Re: BE/148/20/OUT

Nursery Fields, Land to the North of Chalcraft Lane, West Bersted, PO21 5TS

Outline application with some matters reserved to provide up to 225 residential units with associated infrastructure, open space and vehicular and pedestrian access.

SITE ACCESS PLAN (REF: ITB14244-GA-009)

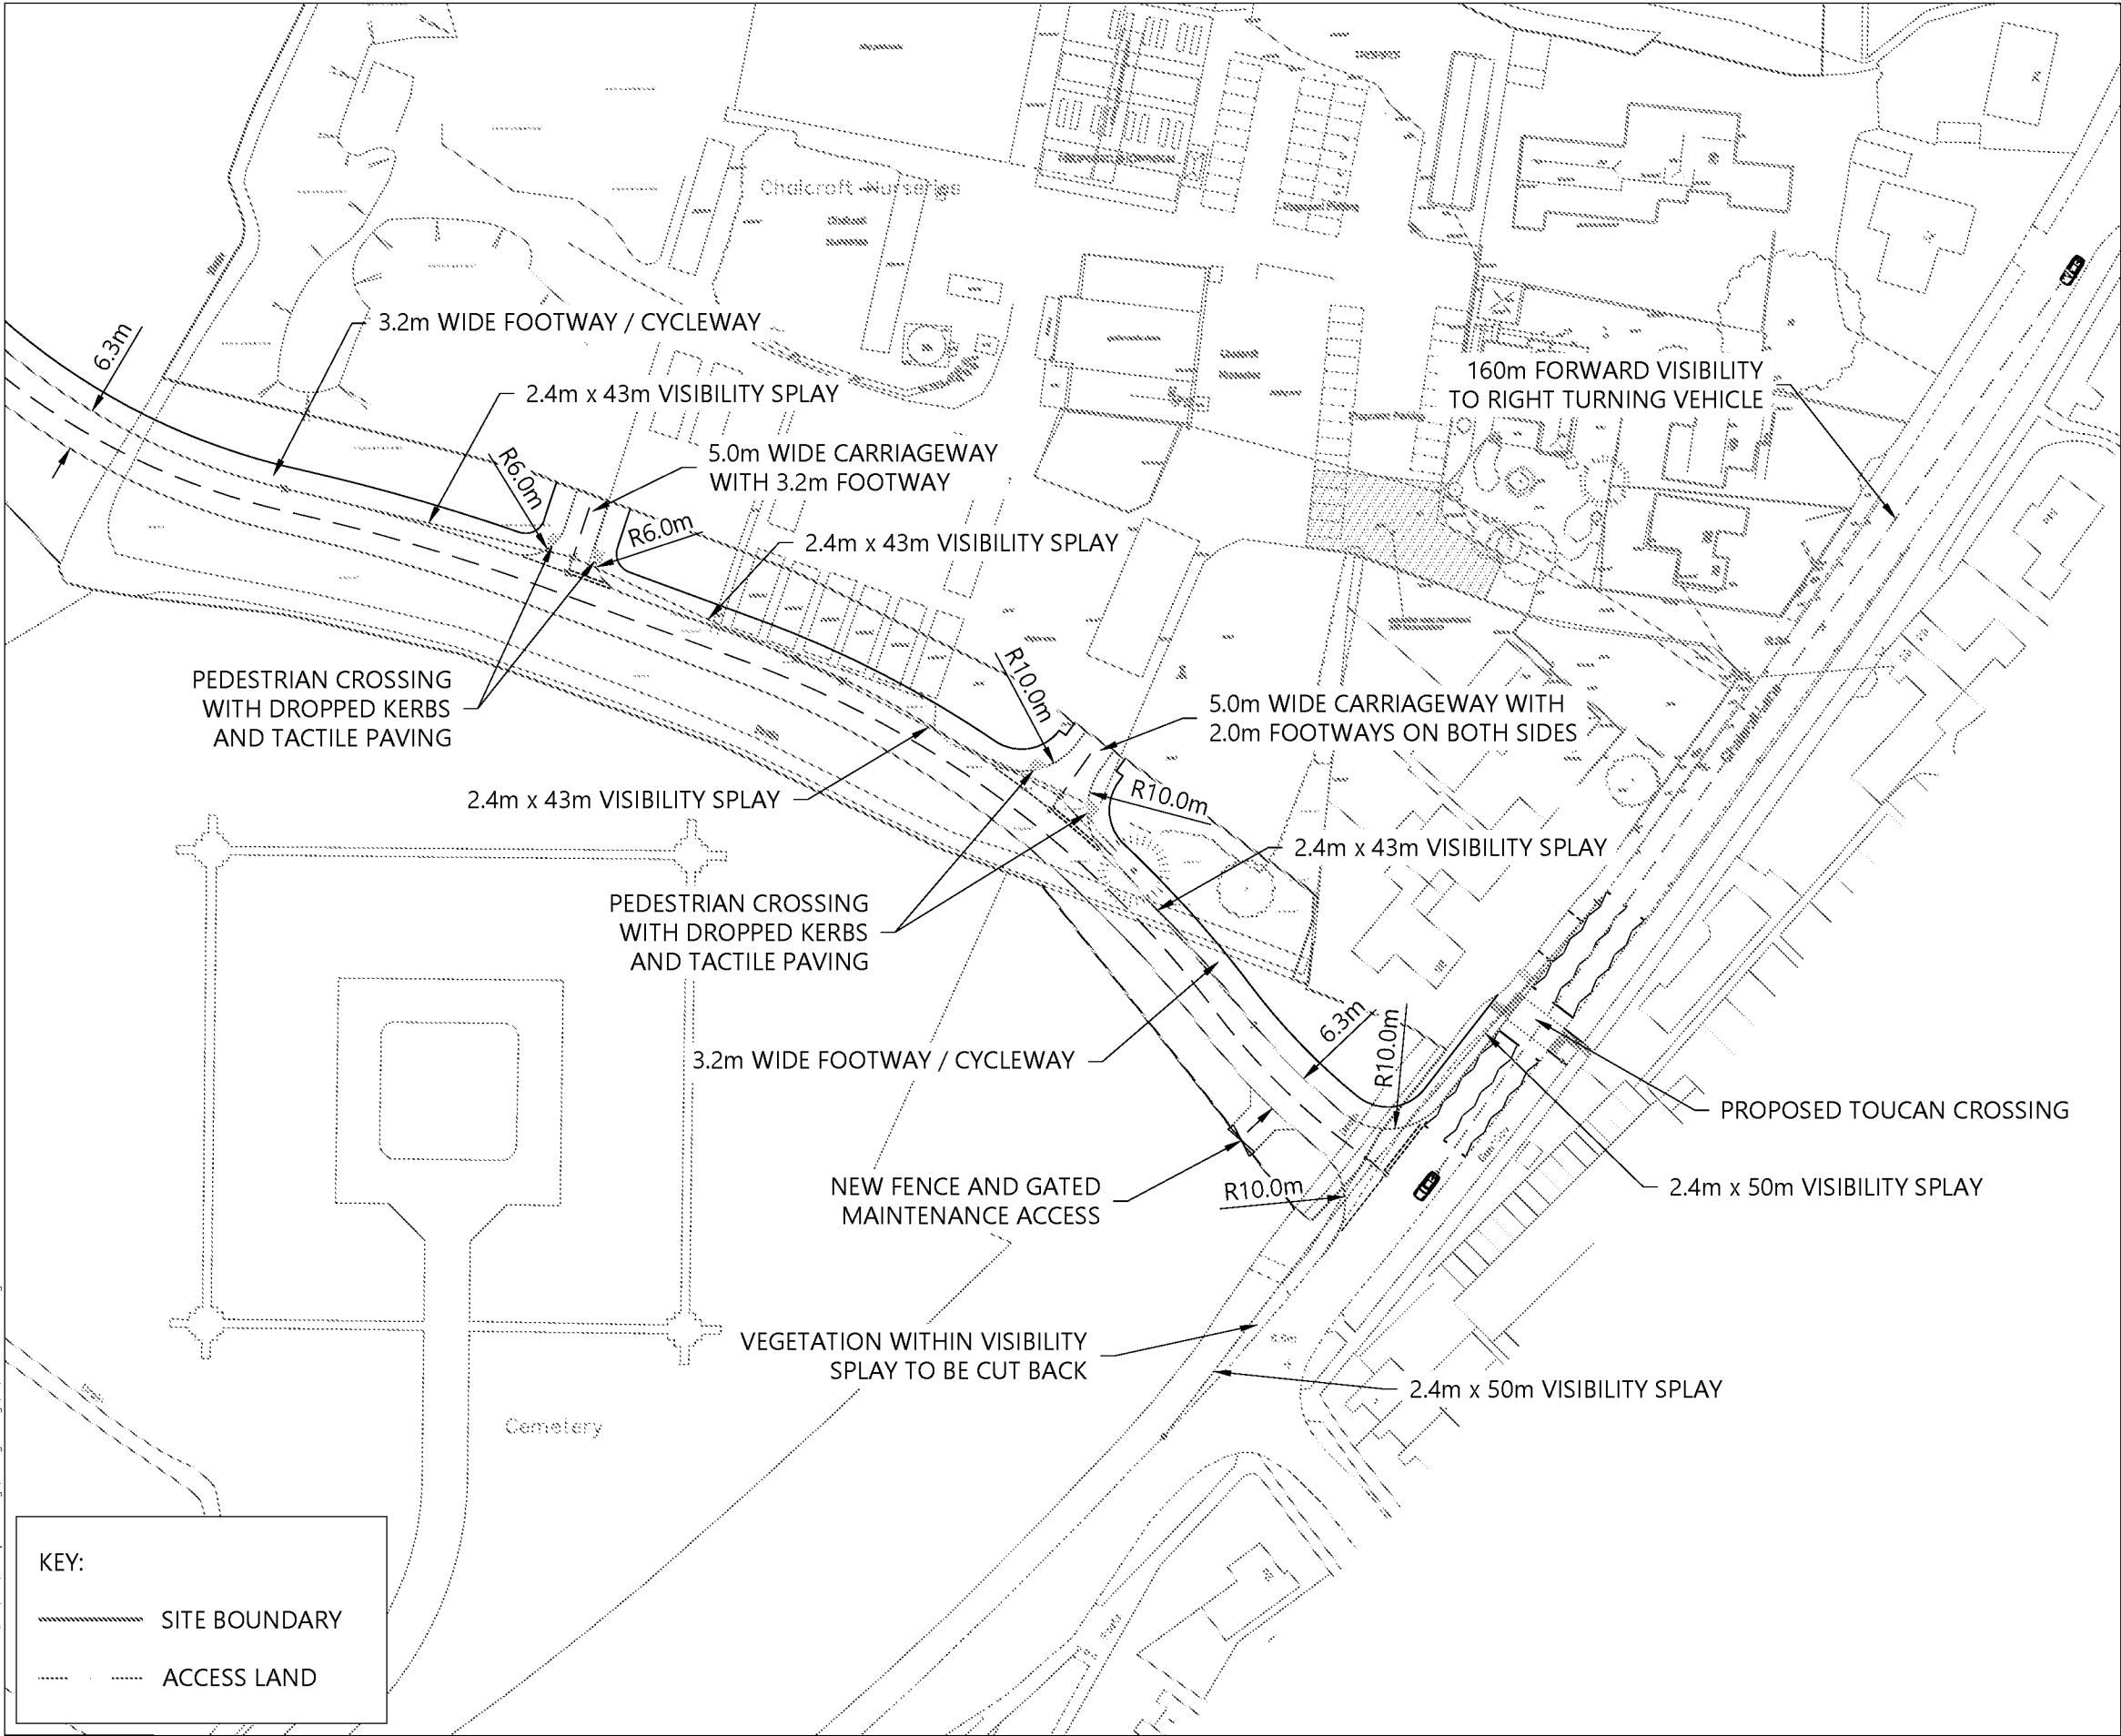
- The proposed access from Chalcroft Lane, shared with the application Chalcroft Nursery site BE/18/20/OUT, as a simple junction with no signal controls, is consistent with the West Bersted Framework Masterplan. Clarity is given in the Transport Assessment that traffic data collected in 2018 has been subject to an allowance for growth associated with committed development totalling 1,214 dwellings and 1,542 sqm of commercial development. Additionally, the TA states that whilst bus links and/or emergency vehicle access might be a future consideration for cross boundary connection, the proposed access has been designed to accommodate only the assessed vehicle numbers associated with the Nursery Fields application and that of Chalcroft Nursery BE/81/20/OUT.

- The Board would encourage the early prioritisation of the proposed Toucan crossing installation to enable safer use of existing pedestrian and cycleways along Chalcroft Lane during the construction phase.
